Barlings Beach Modification 6 – PPG response to submissions

BARLINGS BEACH
STAGE 5A
FUNCTIONAL PLAN
LOT LAYOUT
 BARLINGS BEACH COMMUNITY PTY. LTD
 EUROBODALLA SHIRE COUNCIL
Rev C
Dwg No 142468G1-2

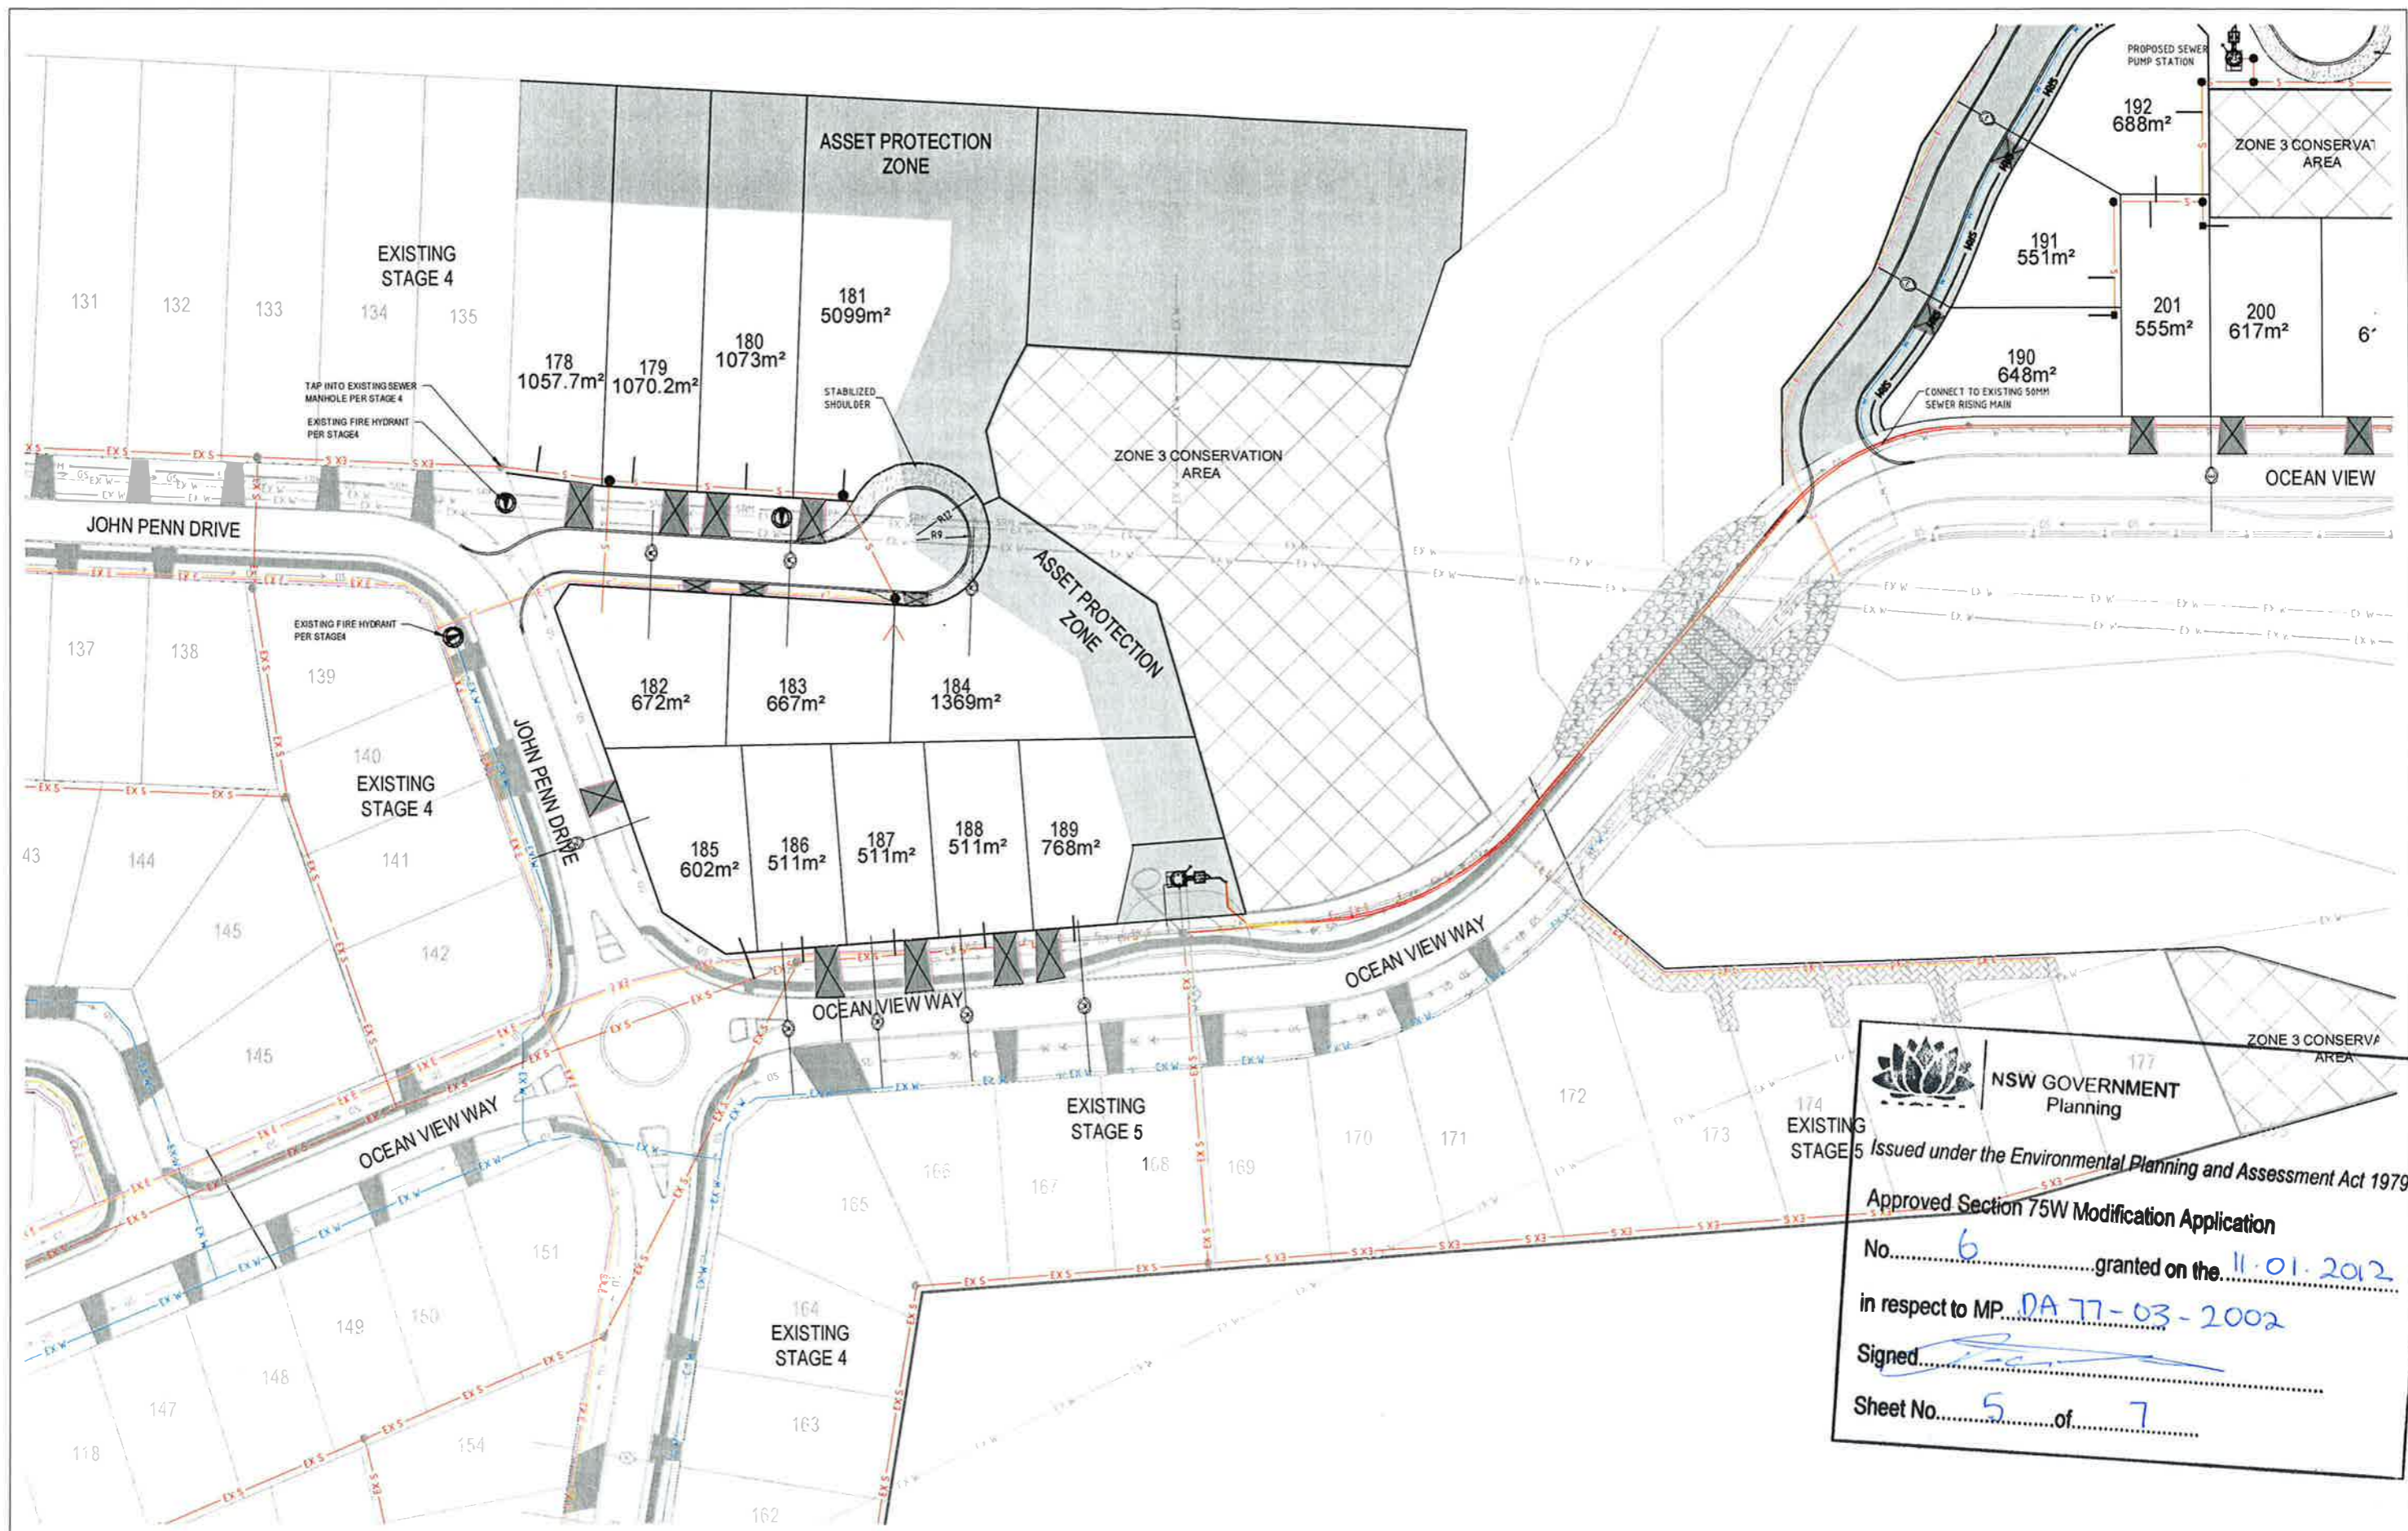
1.5 It is requested the cul-de-sac heads be constructed to full pavement standard (pavement design plus asphaltic concrete top course) and satisfy RFS requirements for 12.5m turning radius.	Noted. The turning circles have been designed to satisfy RFS requirements.
